March 2, 2021

Subject: Response to Review Comments
Solace Apartment Complex
Powers Boulevard and Galley Road
Colorado Springs, Colorado
CTLT Project Nos CS19163.000-105

OVERALL SITE PLAN

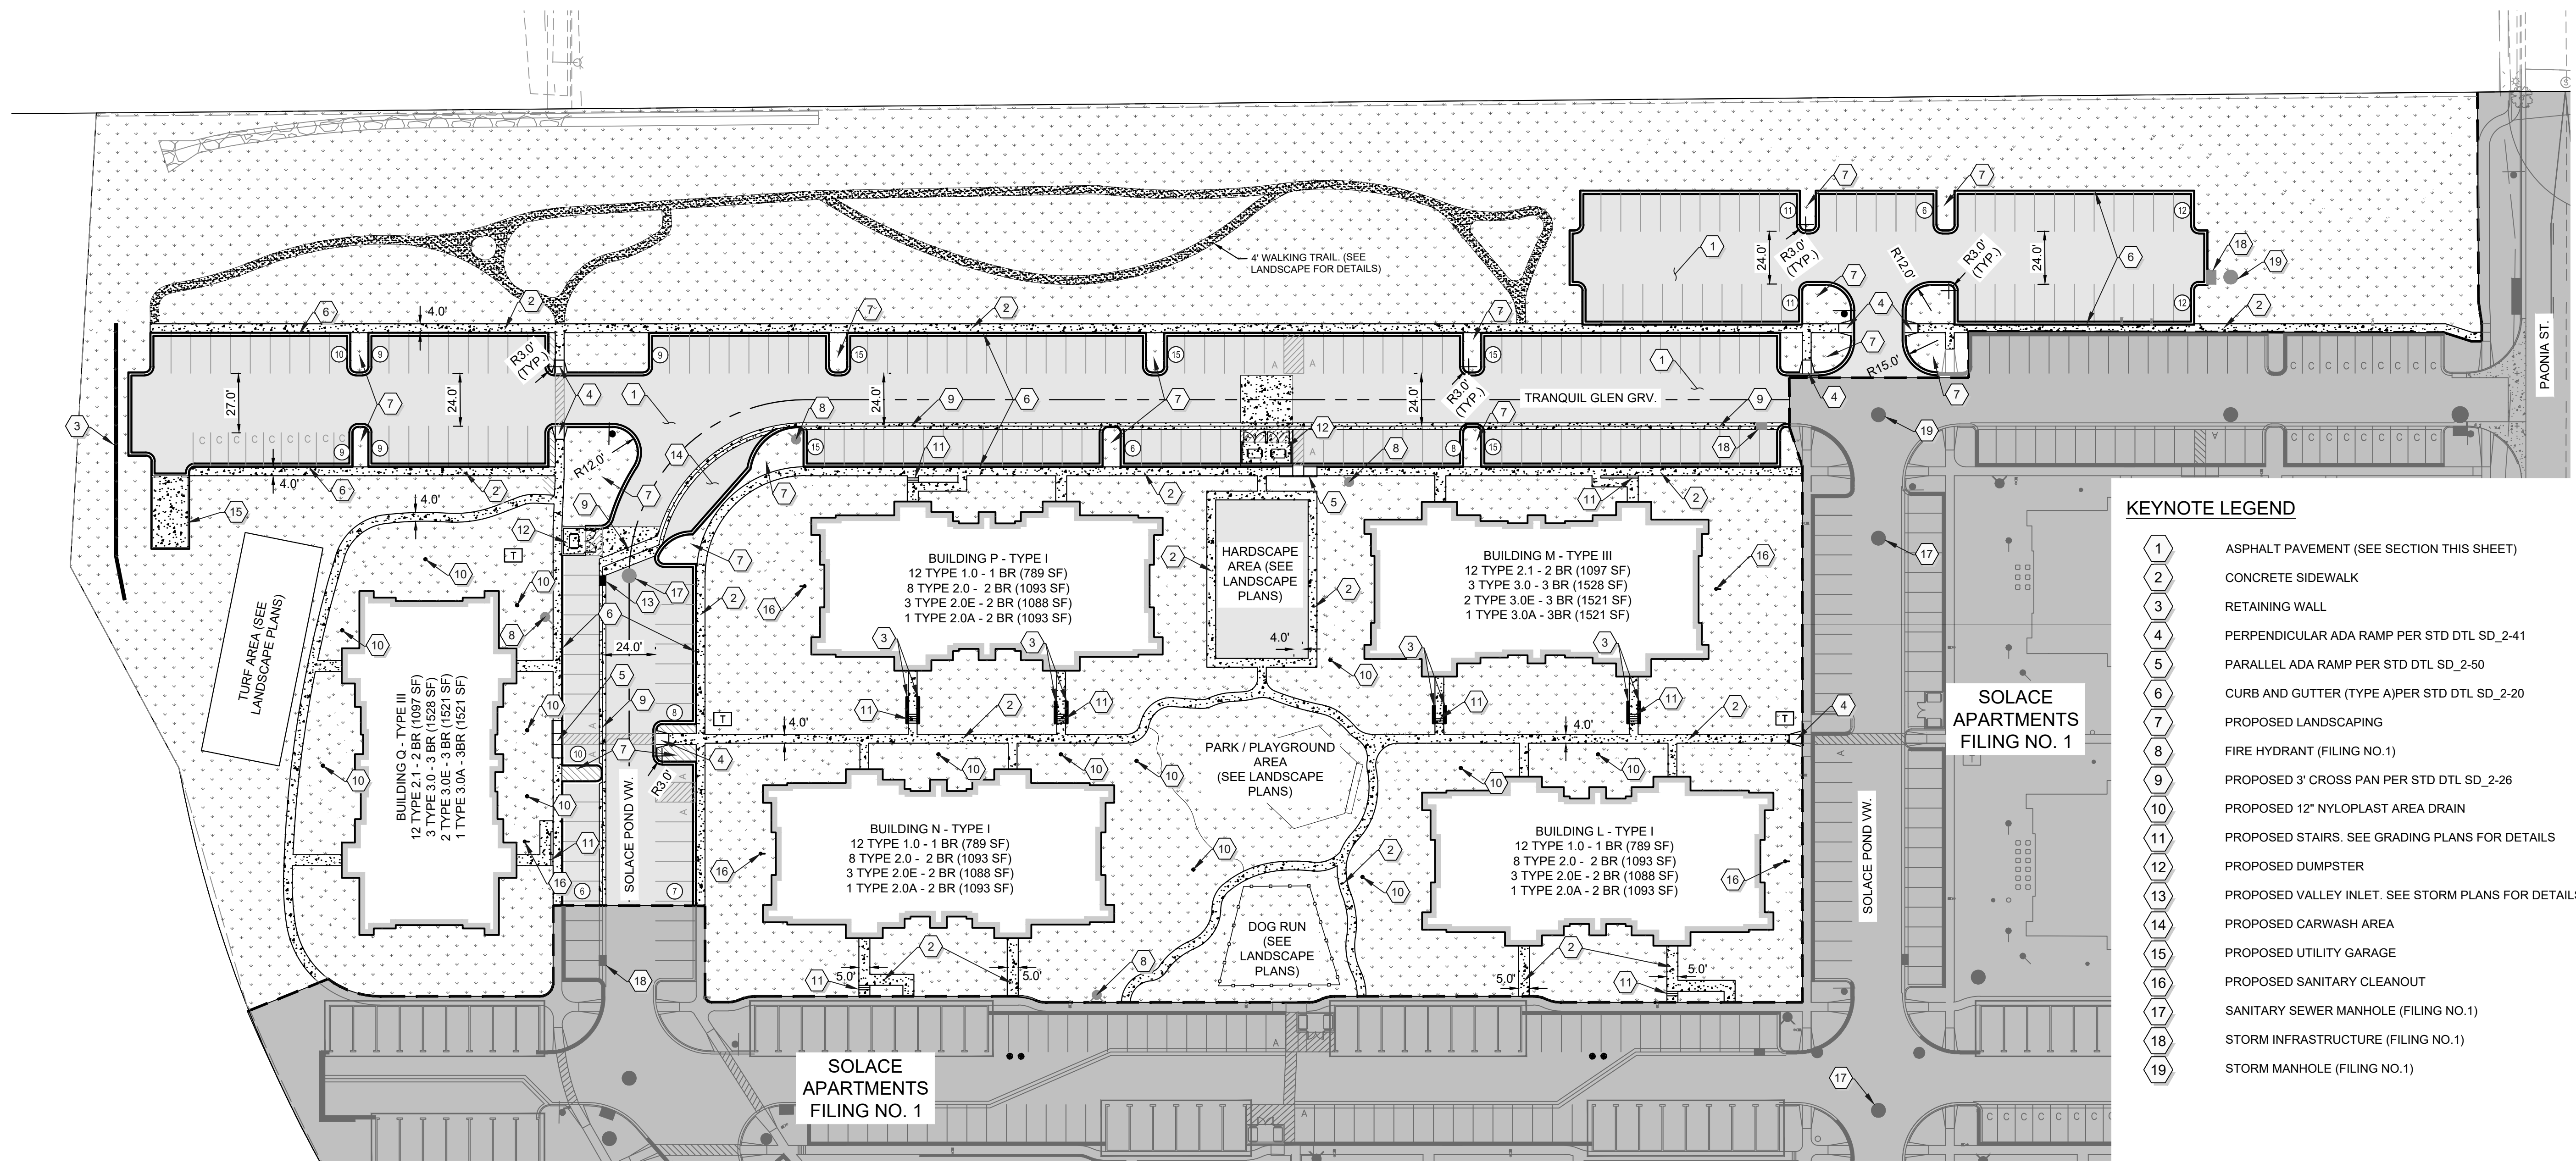
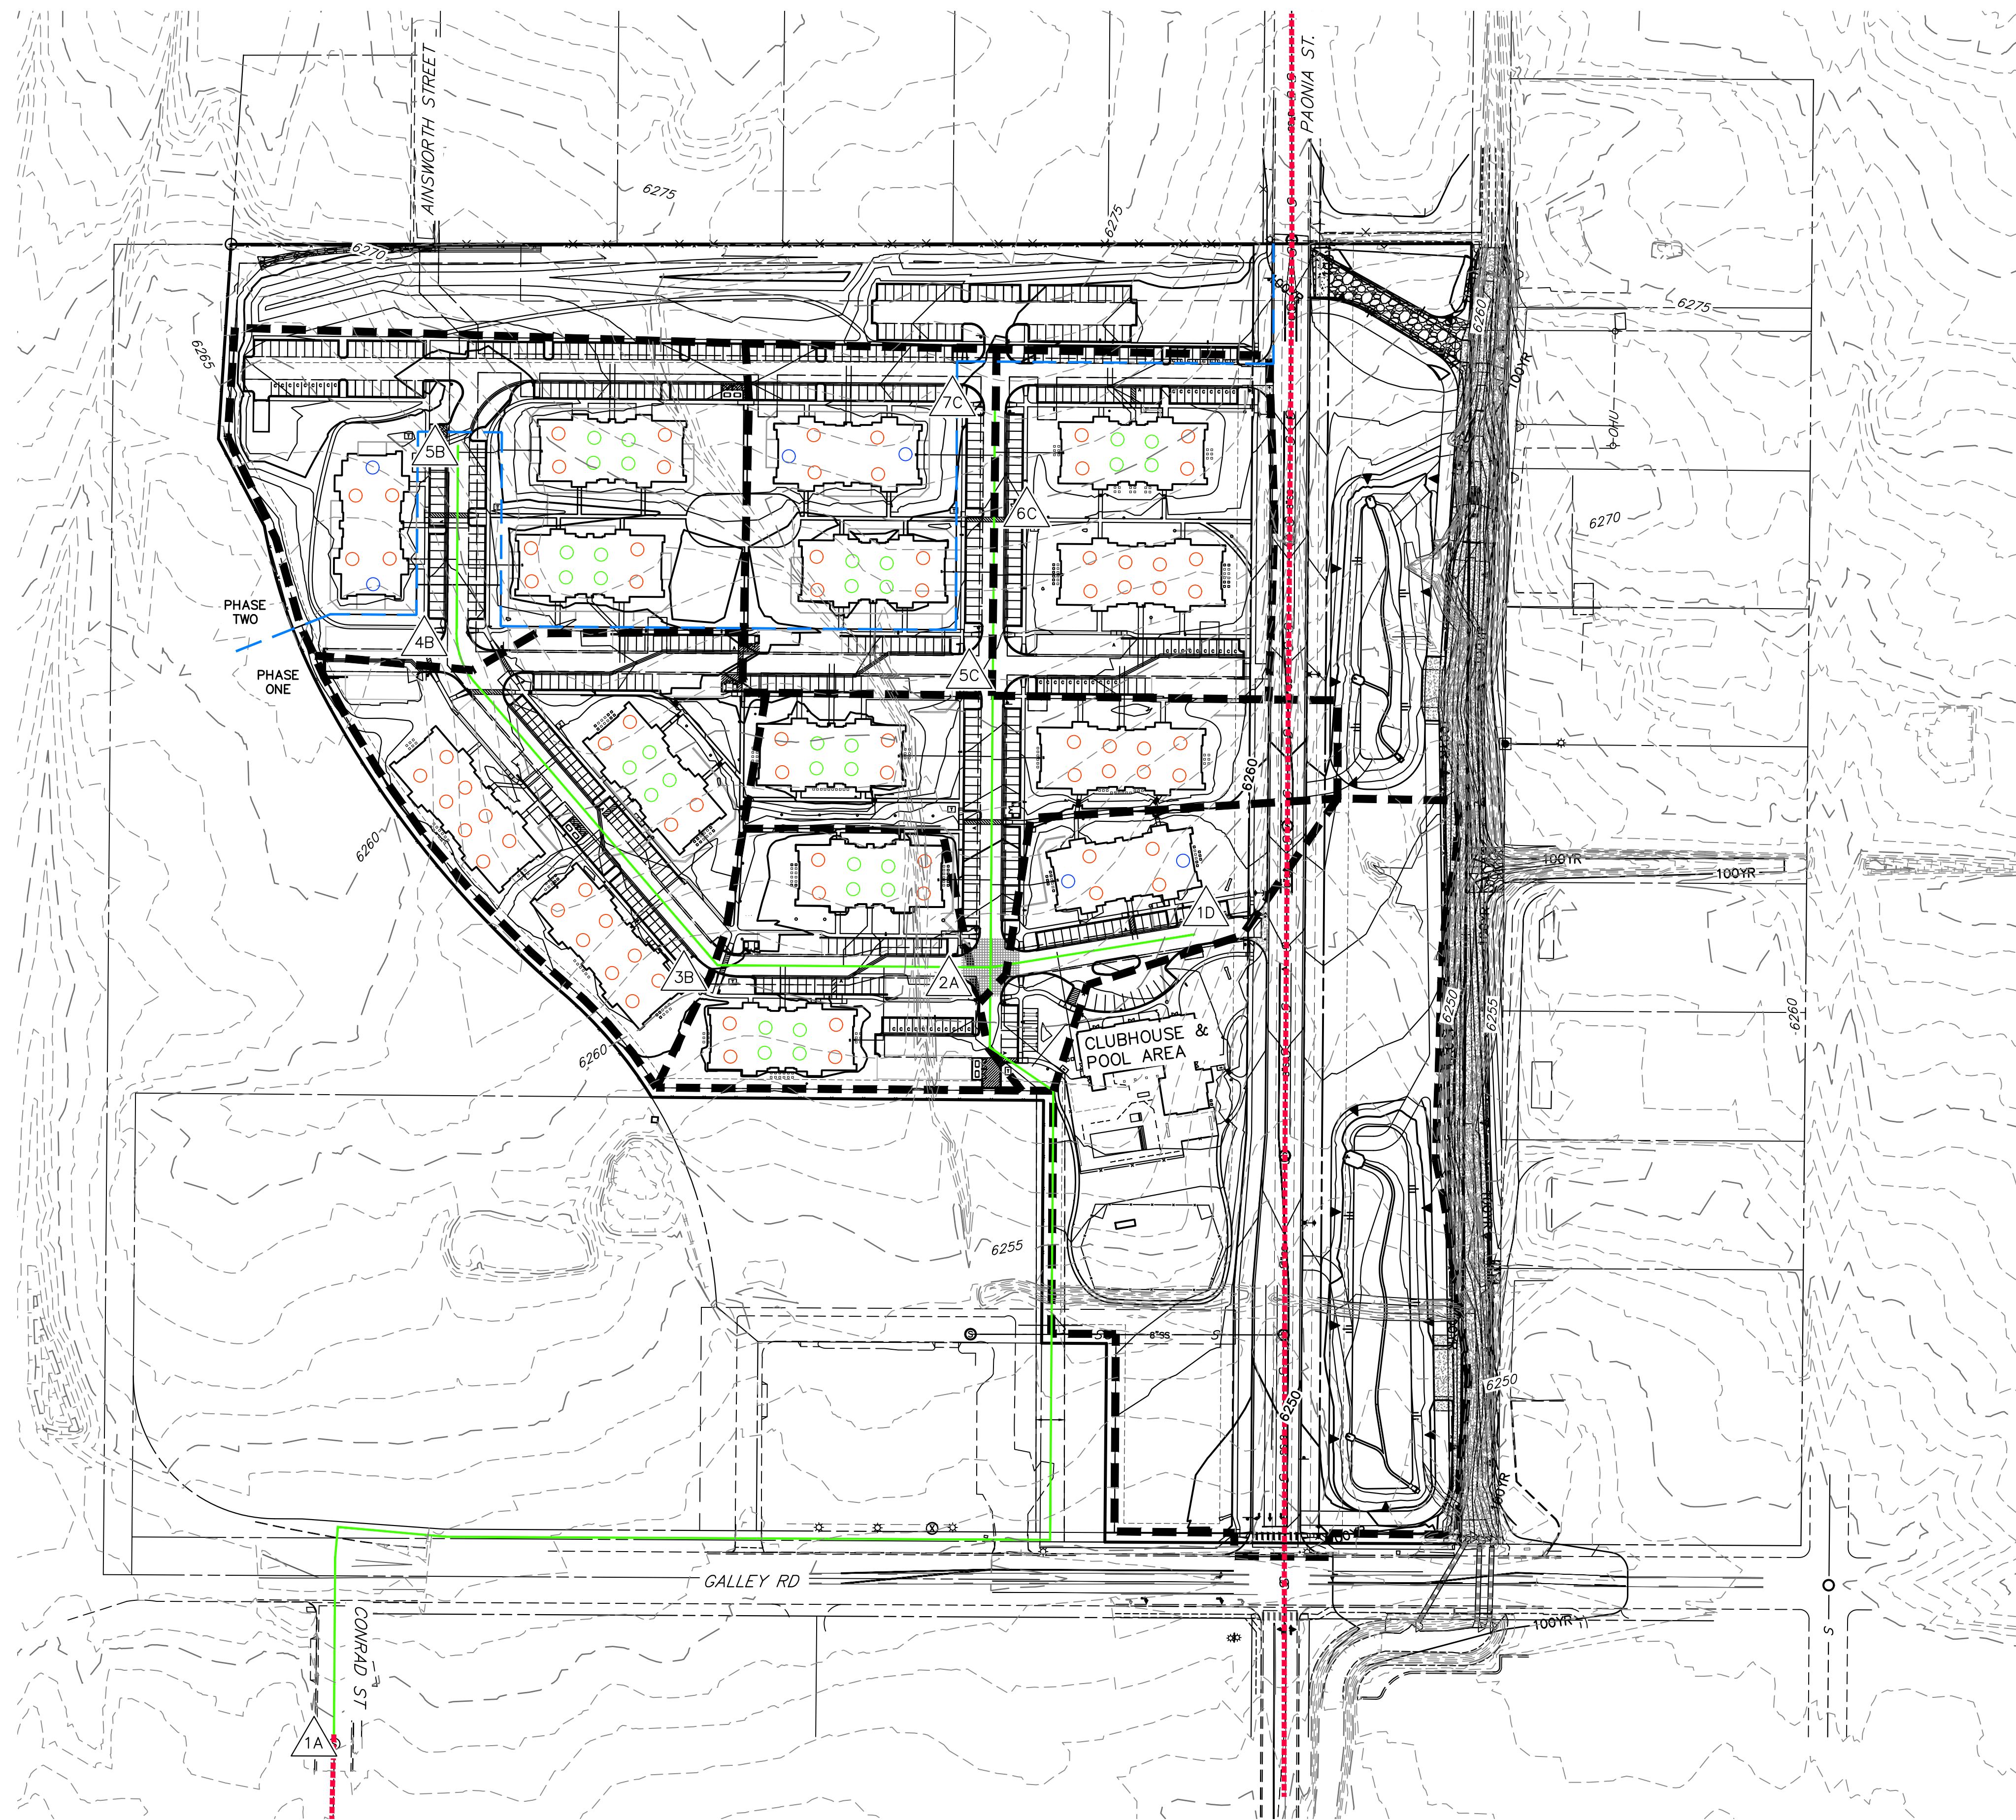
Comment: Per the submitted construction documents the embankments appear to be larger than 5 ft in height. Please coordinate the project civil engineer and revise your analysis accordingly.

Comment: Please also provide recommendations for embankment along the channel as some of the slopes are 2:1. Coordinate with the project civil engineer.

Response: The updated construction plans indicate embankment heights of about 5-feet and cuts below the embankments of about 4 feet to create the overall pond volume. The proposed embankment slopes are flatter than 3:1 (horizontal to vertical). We believe this layout is consistent with recommendations made in our reports.

Response: We have reviewed the updated construction plans and the channel embankments with slopes greater than 3:1 (horizontal to vertical) appear to be lined with concrete. The concrete lining will stabilize the surficial materials at the side slopes. The proposed conditions are considered acceptable from a geotechnical point-of-view.
